From: Neil Whitton
Sent: 02 December 2020 11:46
To: Gemma Magnuson
Cc: DC Support
Subject: 20/02816/LB - The Lion Main Street Wendlebury Bicester OX25 2PW

Environmental Protection has the following response to this application as presented:

Rev	Date	Signed	Amendments	Approved
			<b>sound levels</b>	
			<b>annotation &amp; side elevation</b>	
<i>PROPOSED VENTILATION SYSTEM</i>				
<i>GREASE/ODOUR REDUCTION</i>

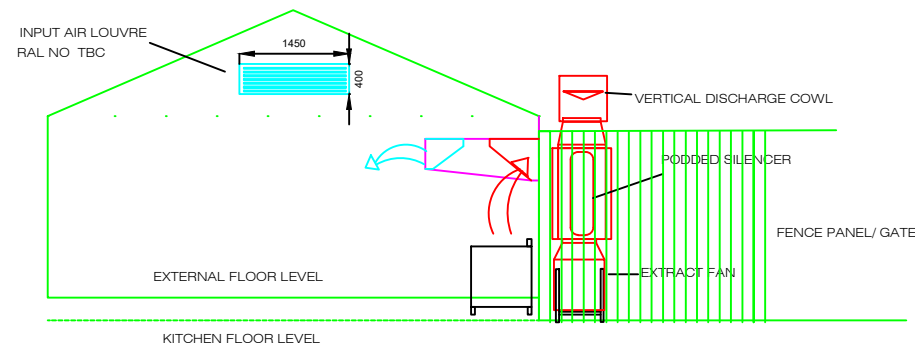
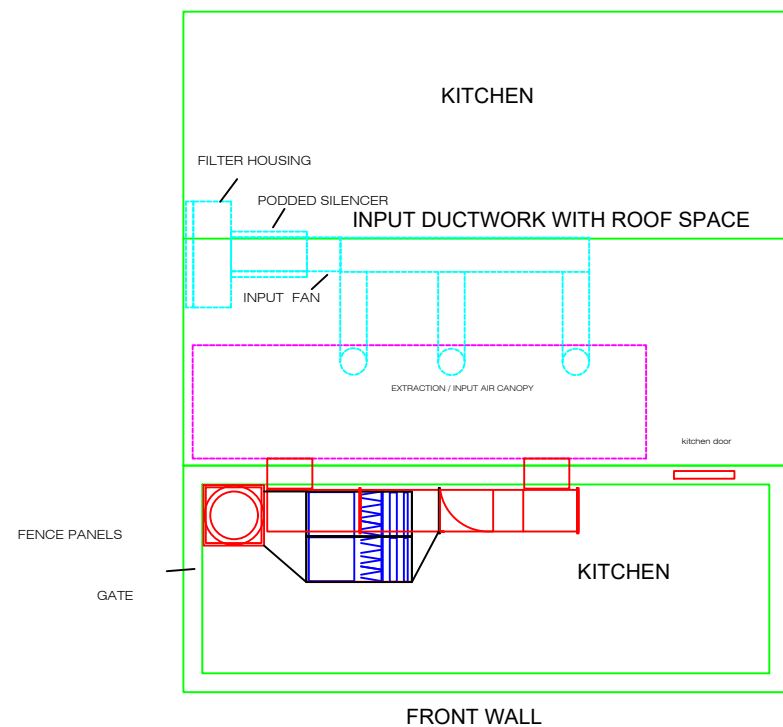
Odour: There have been complaints made to this department regarding odour from the current system, not helped by the positioning of the extract fan pointing down the roof towards the nearby residential properties. Notwithstanding these complaints, odour is an area that we need to comment on and as the extraction system proposed is extracting at a lower level due to the listed building status and to help improve the visual impact of the scheme, the level of odour control for this scheme should be "Very High" based on the guidance provided in the EMAQ Control of Odour and Noise from Commercial Kitchen Exhaust Systems (5/9/2018).

Unfortunately I have been unable to find any information on the odour control. Ideally this would be easy to assess and hopefully approve prior to determination, however if this is not possible then I would recommend that the following condition be placed and on any permission granted:

Details of the odour control for the extraction system shall be submitted to and approved by the LPA prior to the installation of the system. The system shall then be installed as per agreed scheme and maintained and cleaned as per the manufacturers instructions with a log kept of such cleaning and maintenance available for inspection by request of council officers.
